Approval of details reserved by condition imposed under reference A/88/24/S73 relating to condition number 6-height, width and landscaping details of bund along northern boundary with A27.

Land north of Water Lane Angmering BN16 4EJ

Decision:

Arun District Council have decided to **APPROVE details reserved by this condition**

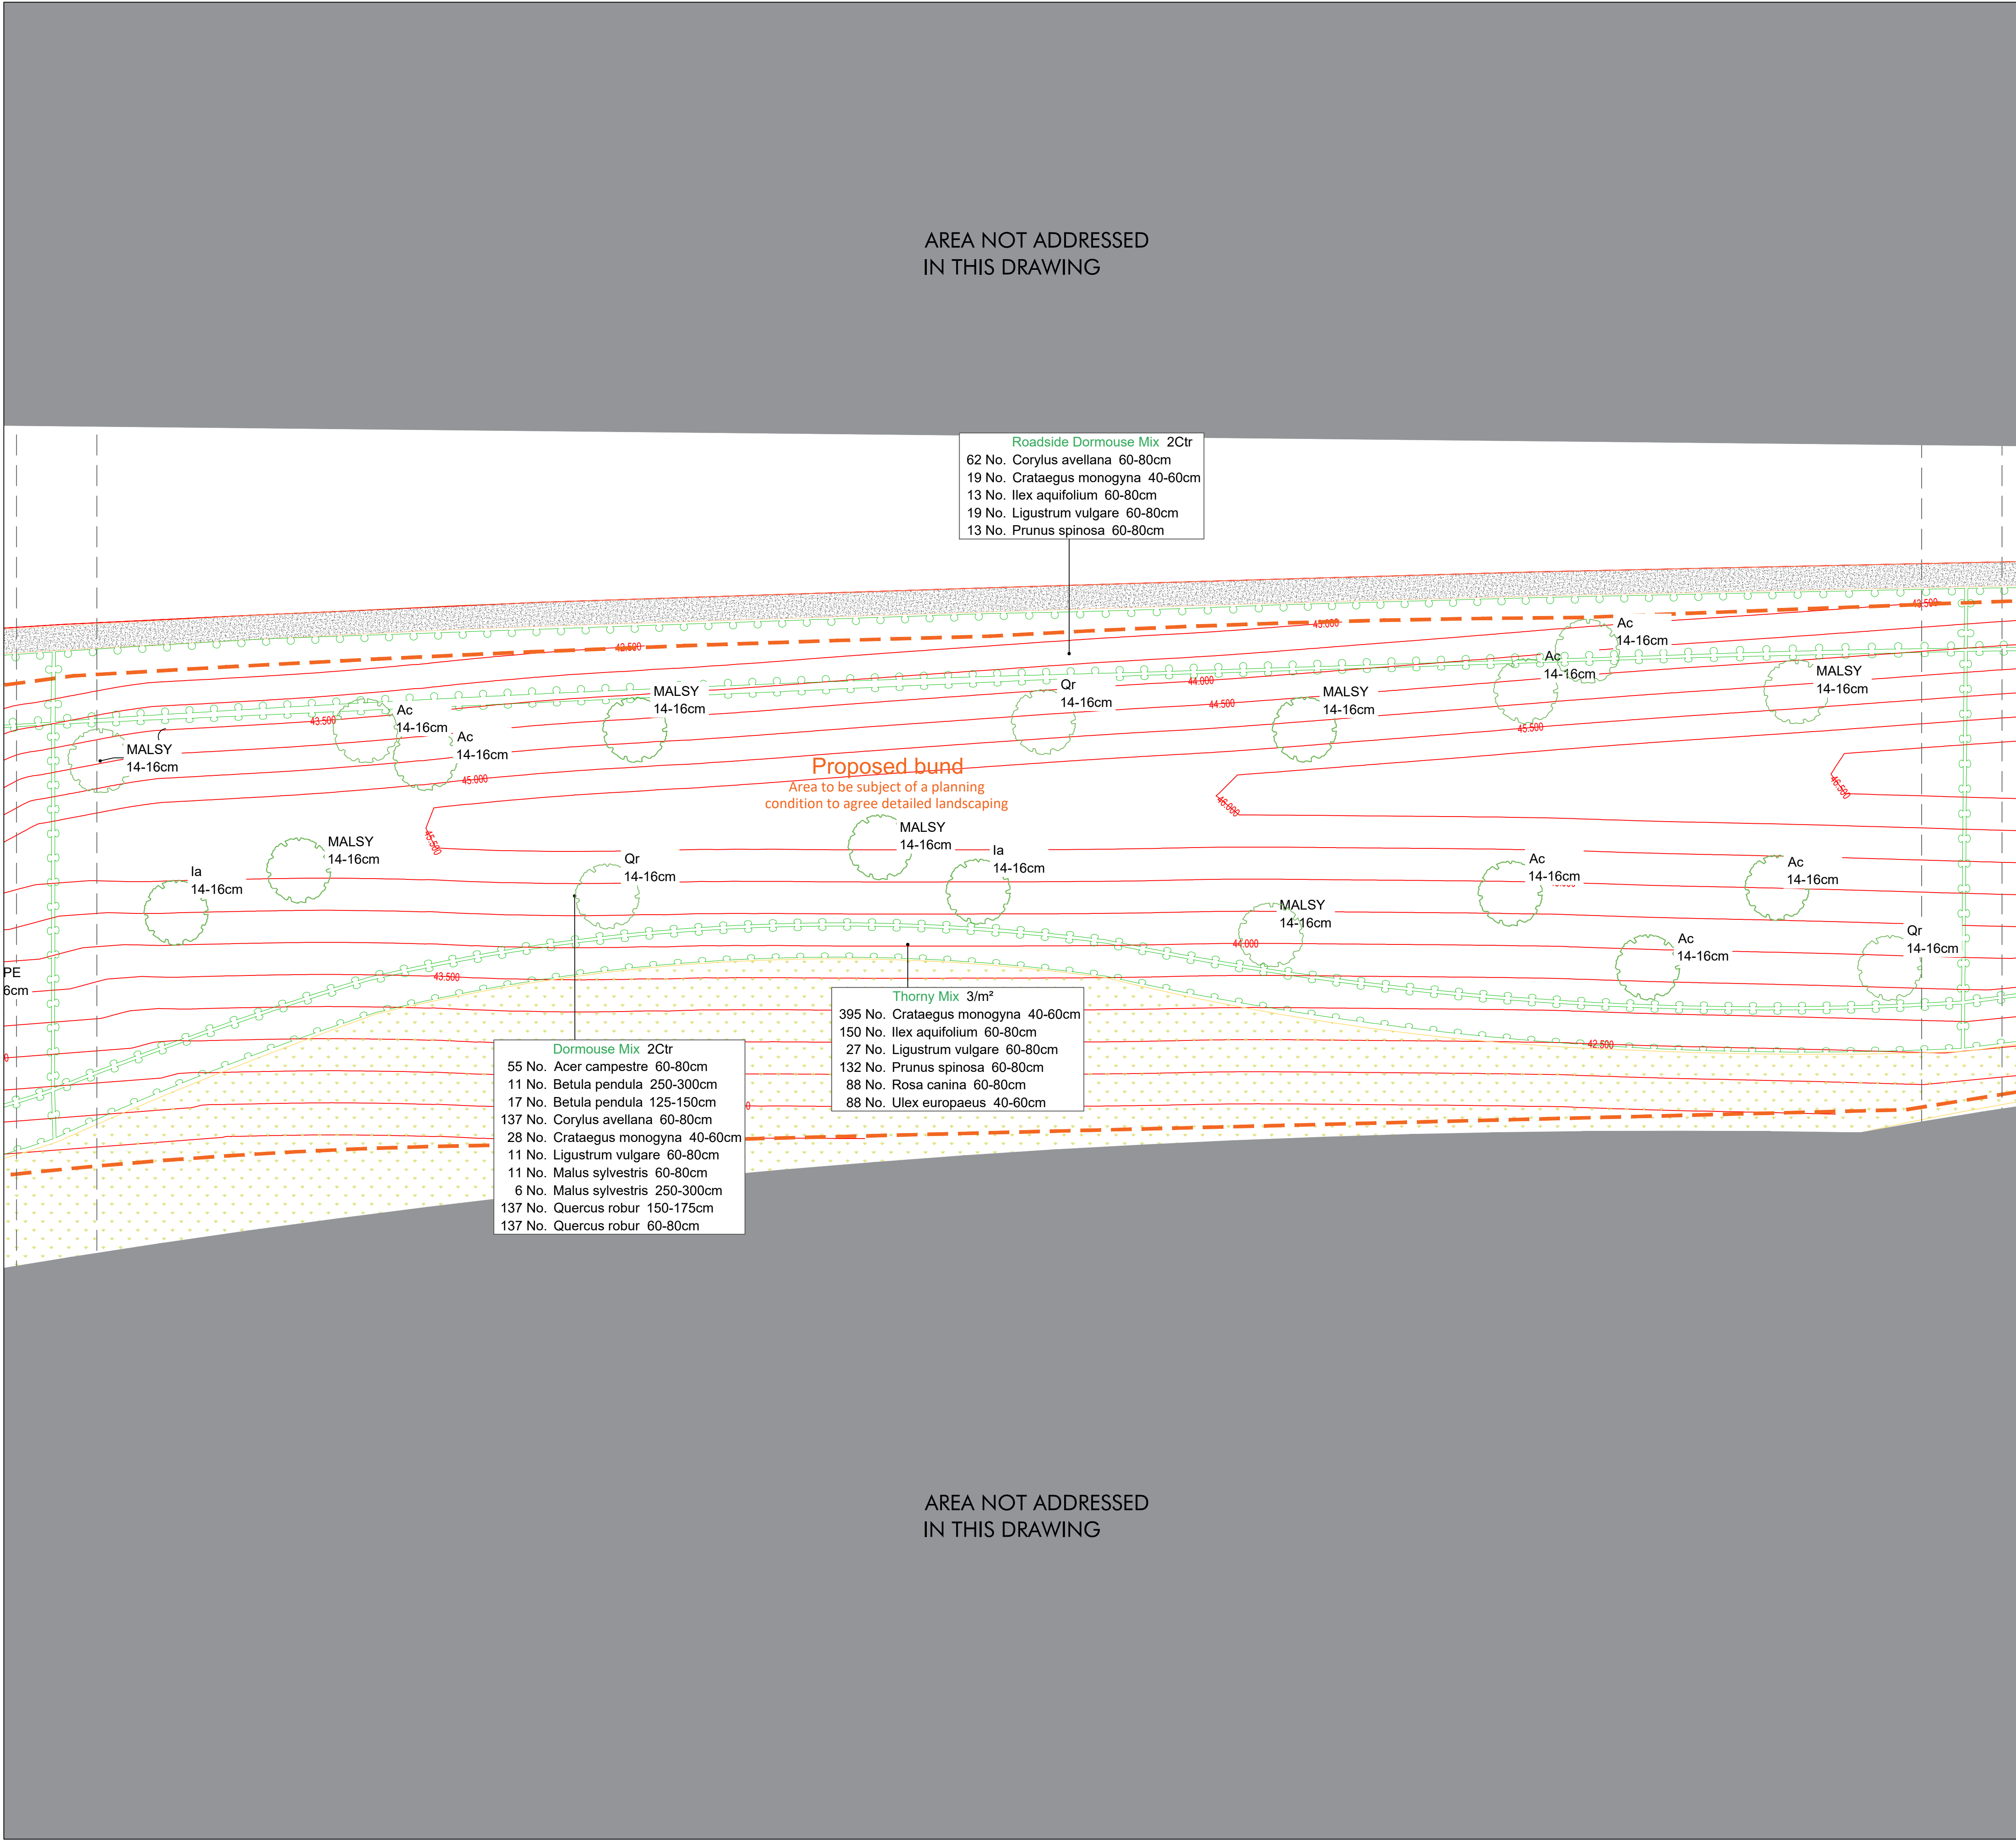
In previous applications, there were concerns that the proposed planting did not provide a mature planting scheme in order to create a strong screening of planting to screen the A27 and aid the transition from the South Downs National Park, help reduce noise of the A27 and provide dormouse suitable habitat within the site. Whilst the Ecologist was satisfied with the dormouse planting at this

time, officers requested additional trees within the scheme closest to the A27 in order to provide a quicker establishment of screening.

This application seeks to address the issues raised previously by increasing the number of individual trees, which is supported, and will allow a thicker canopy on establishment, whilst retaining mixed scrub understorey suitable for dormouse.

The condition requires details of plant species, heights and locations as well as cross sections showing the peak and trough of the bund. This has been provided in full and is acceptable. Therefore, the details below are approved:
